Consultation Response from: KC Environmental Health (Pollution & Noise Control)		
2020/90640 - Holmfirth High School, Heys Road, Thongsbridge, Holmfirth, HD9 7SE		
Formation of artificial grass pitch with associated features, including eight 15m high floodlights, fencing up to 4.5m, pedestrian circulation and access route, vehicular maintenance and emergency access with Springwood Road, erection of store, grass mounds, retaining structures and landscaping works		
Date Responded: 04 May 2020	Responding Officer: Richard Hume	Responding Ref: WK/202006877
Noise A “Noise Impact Assessment Report” by Acoustic Consultants, dated 10 Jan 2020 (Ref: 8082/DO) has been submitted. The report predicts the noise levels that will occur at nearby noise-sensitive properties by using measurements of noise from sports activities at existing similar sports facilities and compares those levels with measurements of the existing noise levels within the site. It advises that the proposals are for the development to be open for use, including use by the community, from 9:00 until 22:00 Monday to Friday and until 17:00 on Saturday, Sunday and Bank Holidays. The assessment predicts highest noise level at the

3.1 Pitch 1 - 200lux: Graphical Table

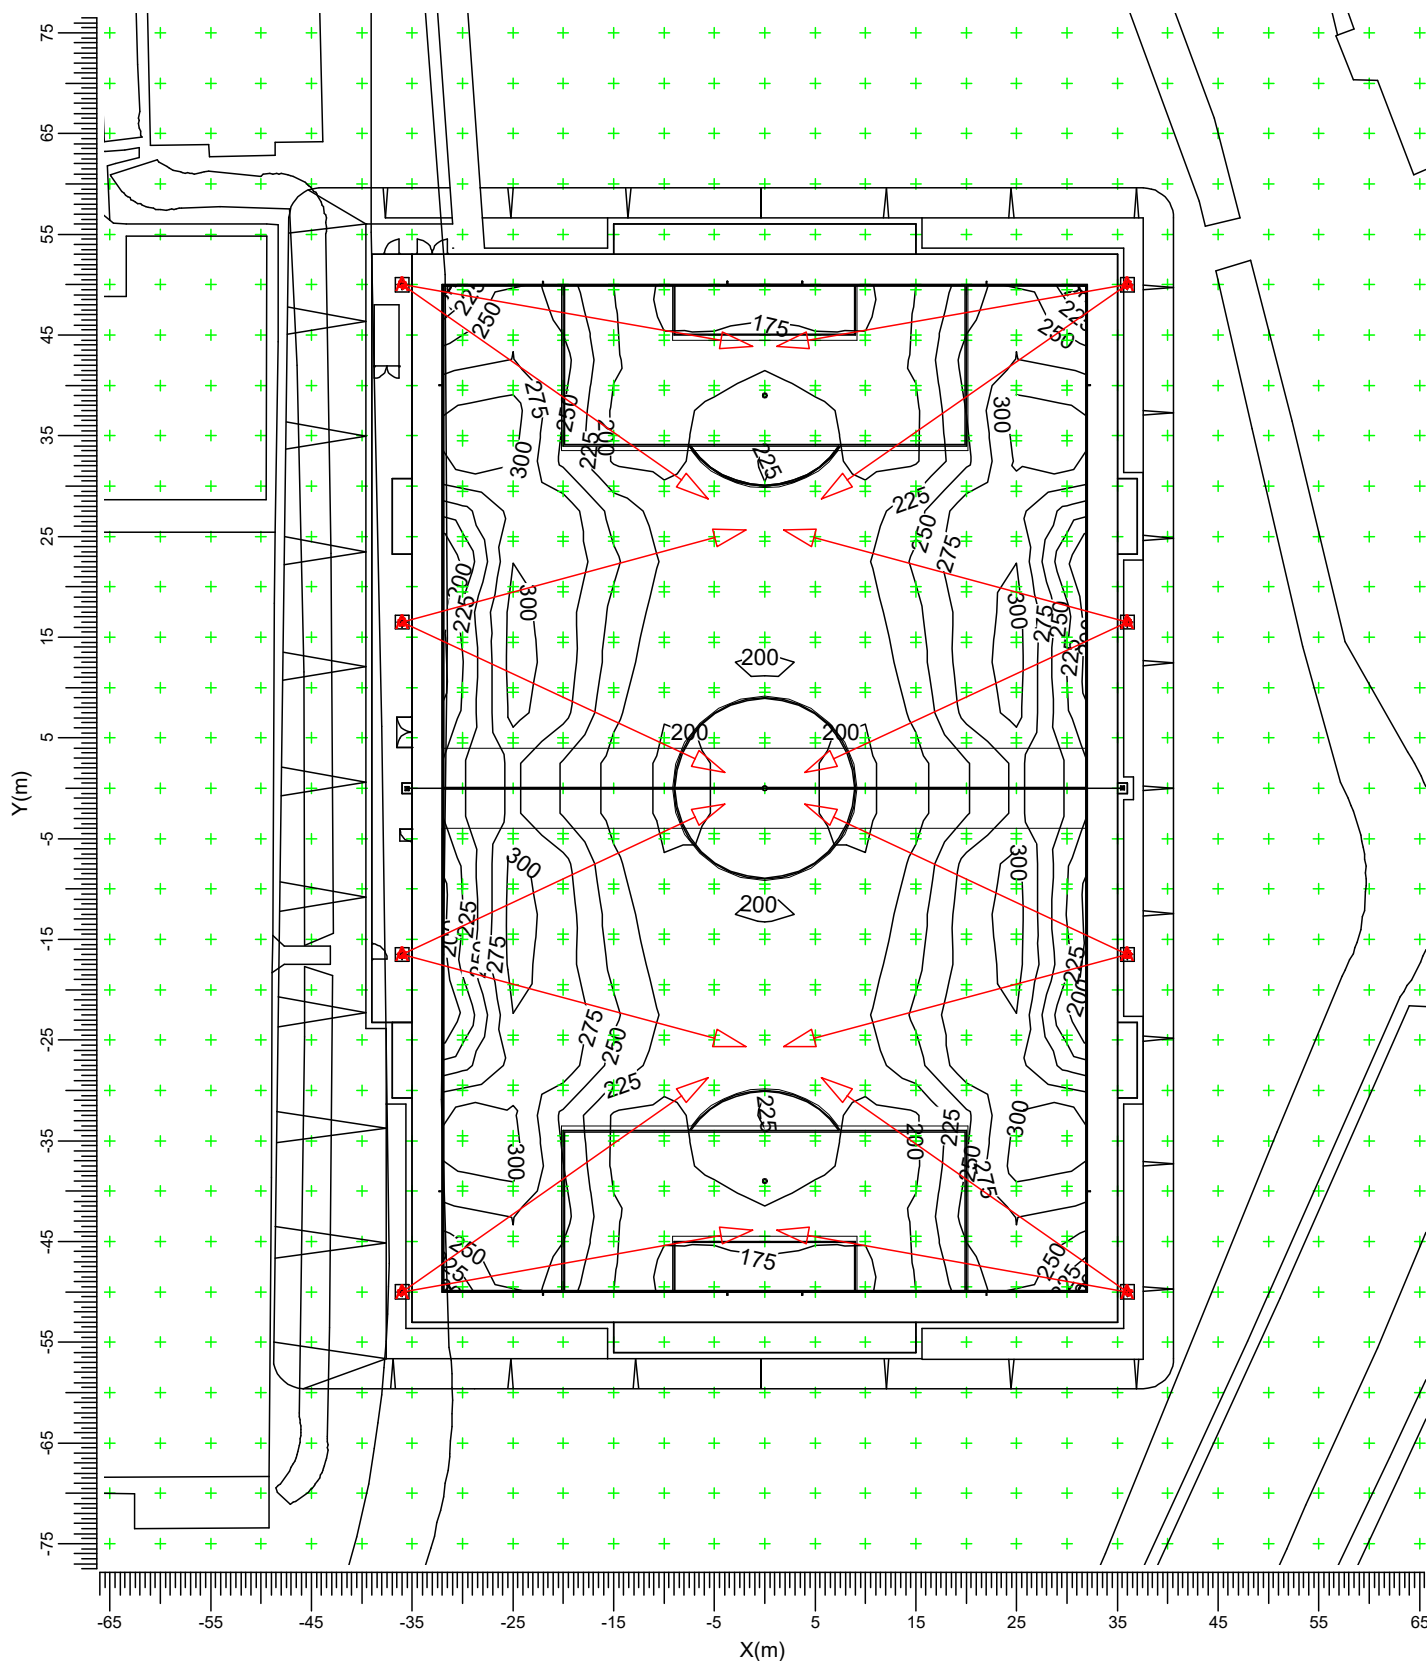
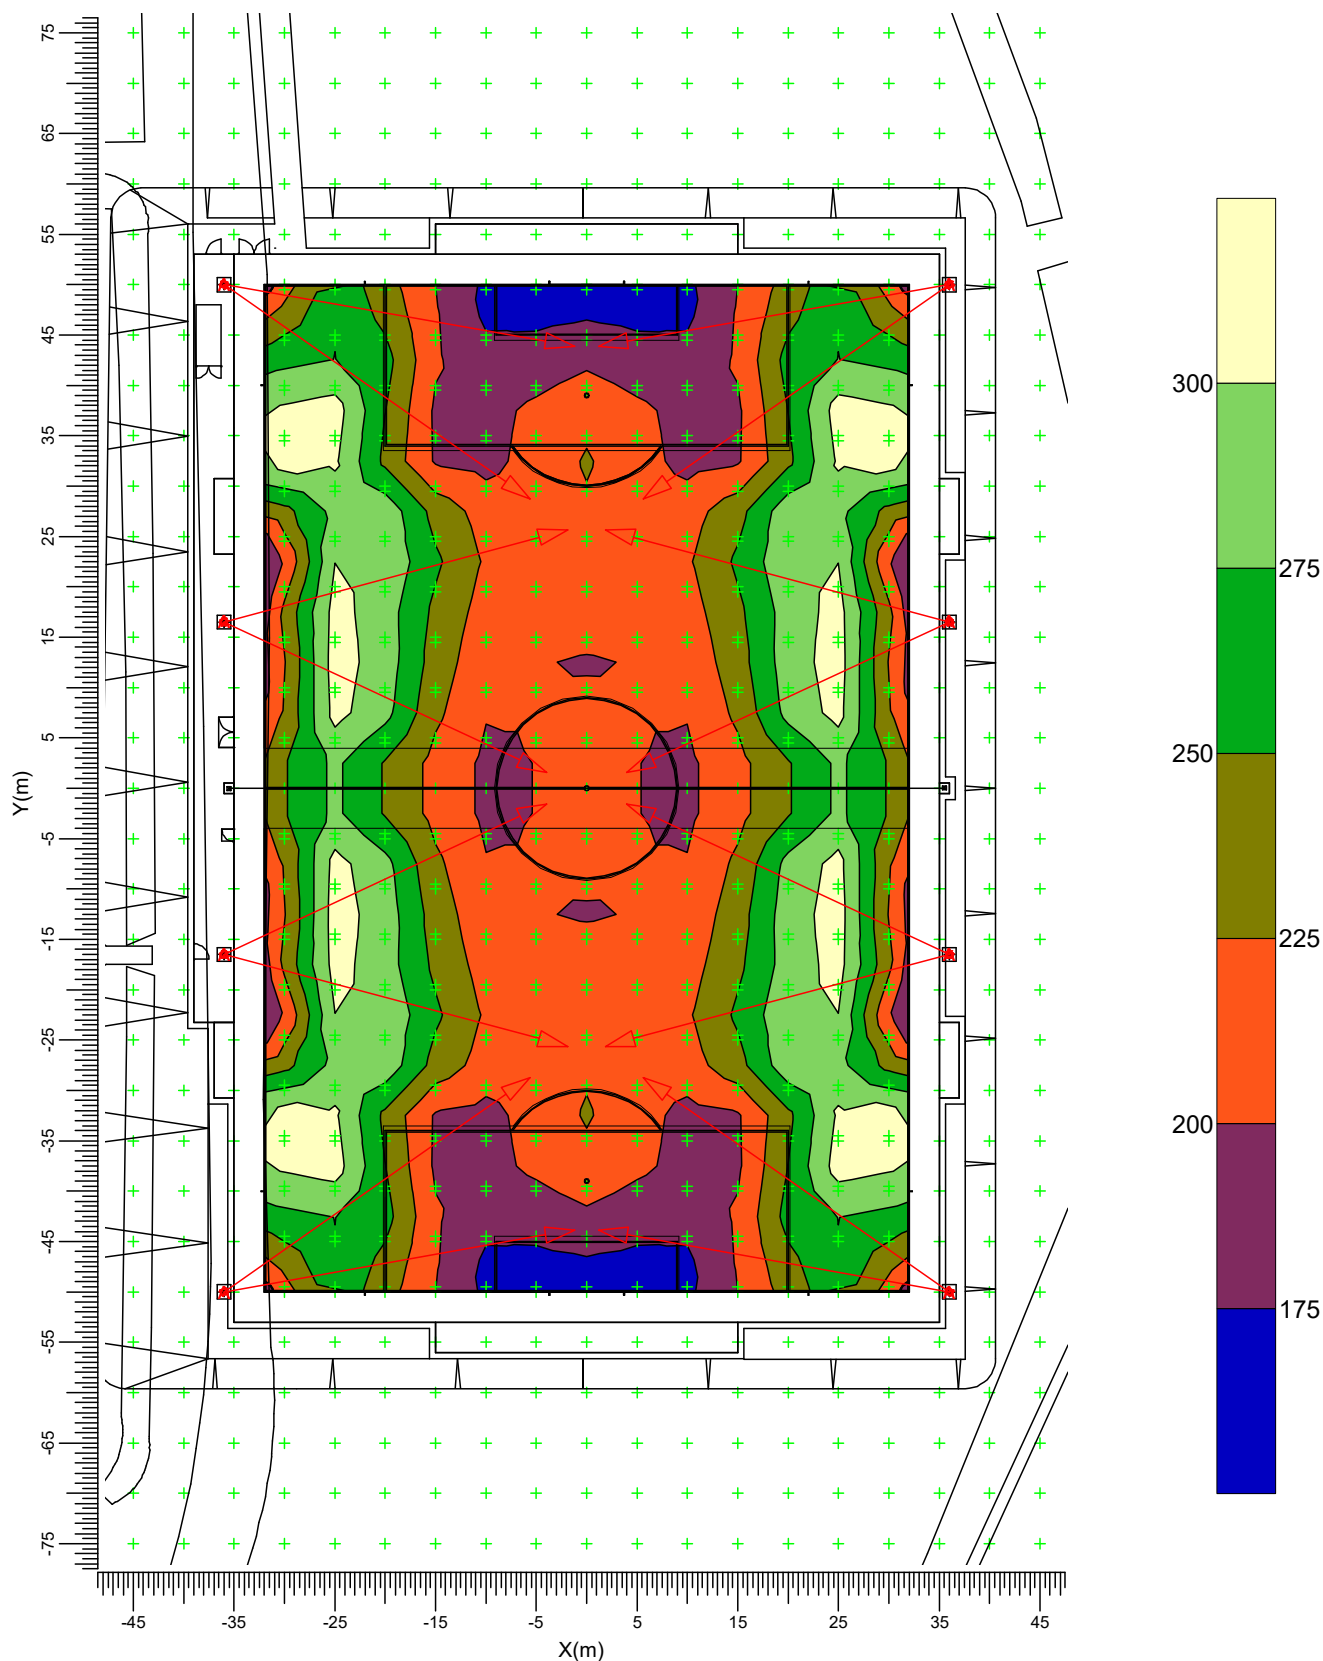
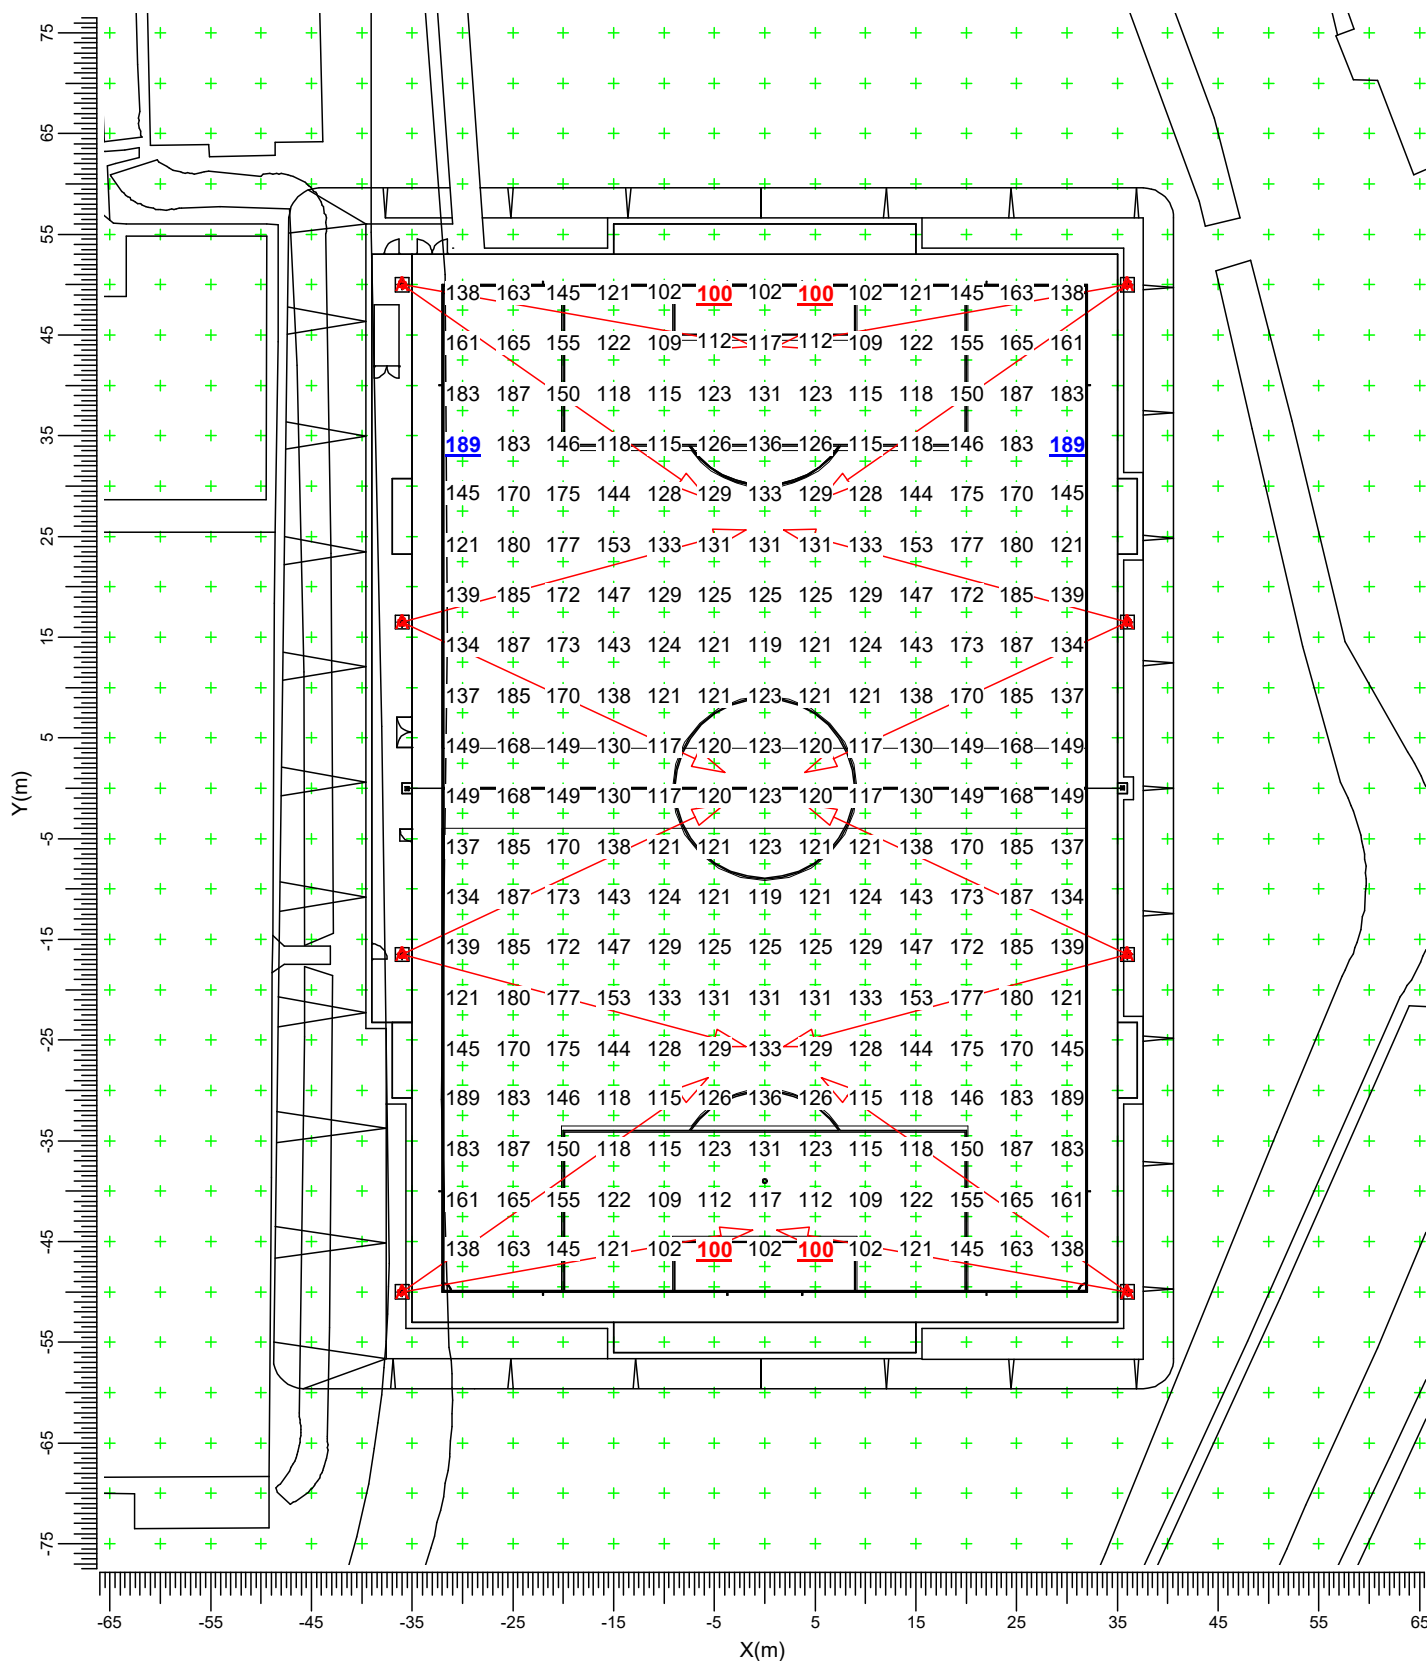
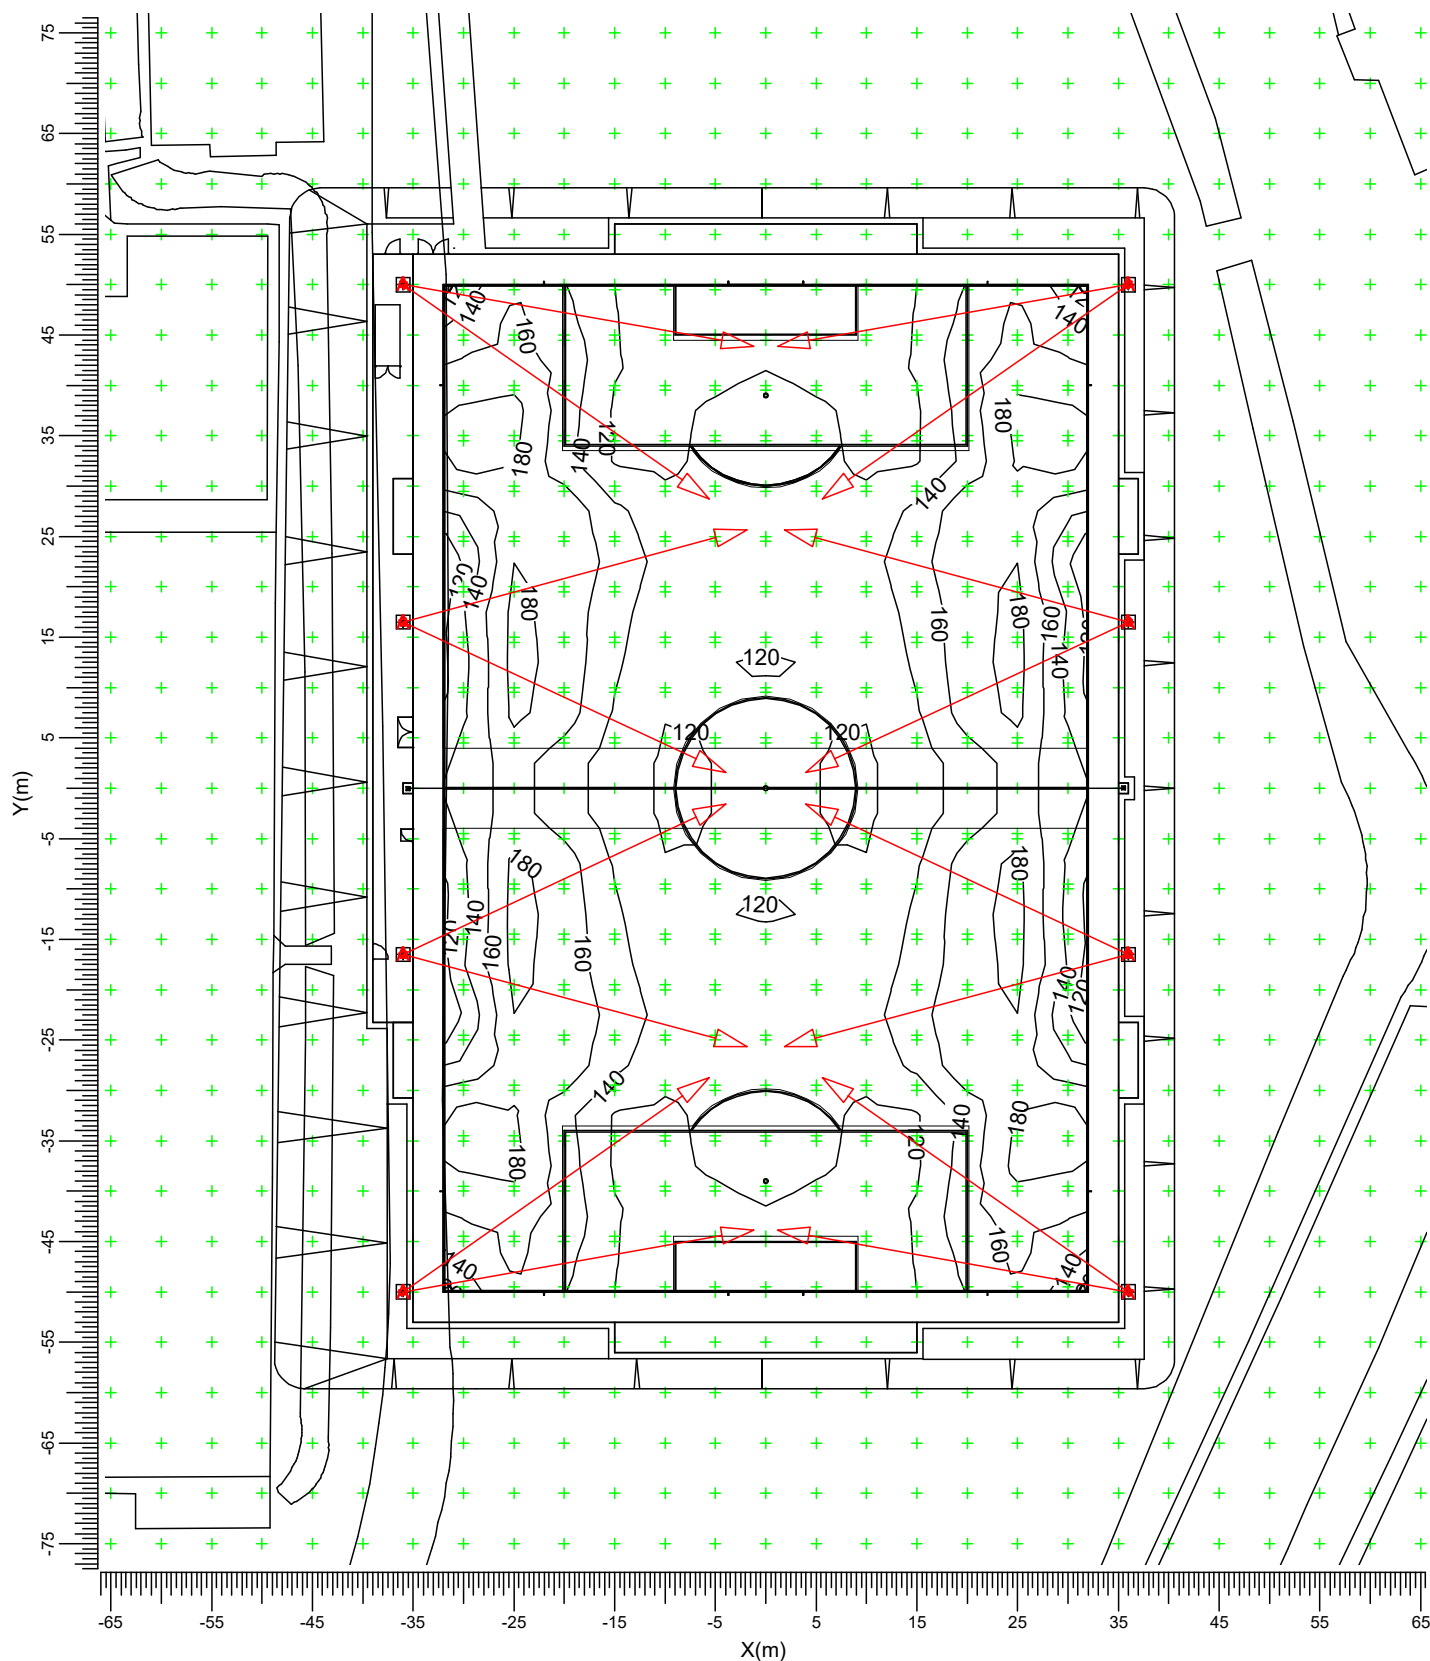
The design levels of illuminance for the pitch are 120 / 200 lux based on football association guidance, and reference is also made to BS EN 12193. The lighting proposals predict that the maintained average illuminance will range from 142 to 237 lux for the whole pitch and 221 lux for when half the pitch is lit, based on a maintenance factor of 0.9. The report indicates, from spillage at ground level and at 1.8m illuminance information, that the proposed lighting will cause illuminance levels of less than 1 lux at nearby residential premises except for 46 Springwood Rd where it predicts it will be 1.38 lux. It is unclear from the information provided, but it is assumed these levels refer to horizontal illuminance. It proposes that the lighting will remain lit for 15 minutes after the pitch use ends, to enable safe egress for users.

There are some concerns regarding the proposed and predicted levels of illuminance. The football association guidance which has been used for the design levels of illuminance is intended for lighting installations for Clubs wishing to compete in FA competitions and in the National League System. The British Standard referred to in the submitted document (BS EN 12193 (2018) Light and Lighting - Sports Lighting) provides different guidance, recommending illuminance levels of 75 lux for a development of this type.

I therefore consider that the proposed illuminance levels are significantly higher than are necessary for the intended future use and therefore unacceptable. A condition requiring revised proposals for the artificial lighting are therefore necessary.

Before the installation of external artificial lighting commences, a lighting scheme shall be submitted to and approved in writing by the Local Planning Authority. The scheme should include the following information:-

- a) The proposed hours of operation of the lighting
- b) The location and specification of all of the luminaires
- c) The proposed design level of maintained average horizontal illuminance for the areas that needs to be illuminated.
- d) The predicted vertical illuminance that will be caused by the proposed lighting when measured at windows of any properties in the vicinity.
- e) The measures that will be taken to minimise or eliminate glare and stray light arising from the use of the lighting that is caused beyond the boundary of the site
- f) The methods of switching and controlling the lighting so that it is only operated at the permitted times and at times when it is required.
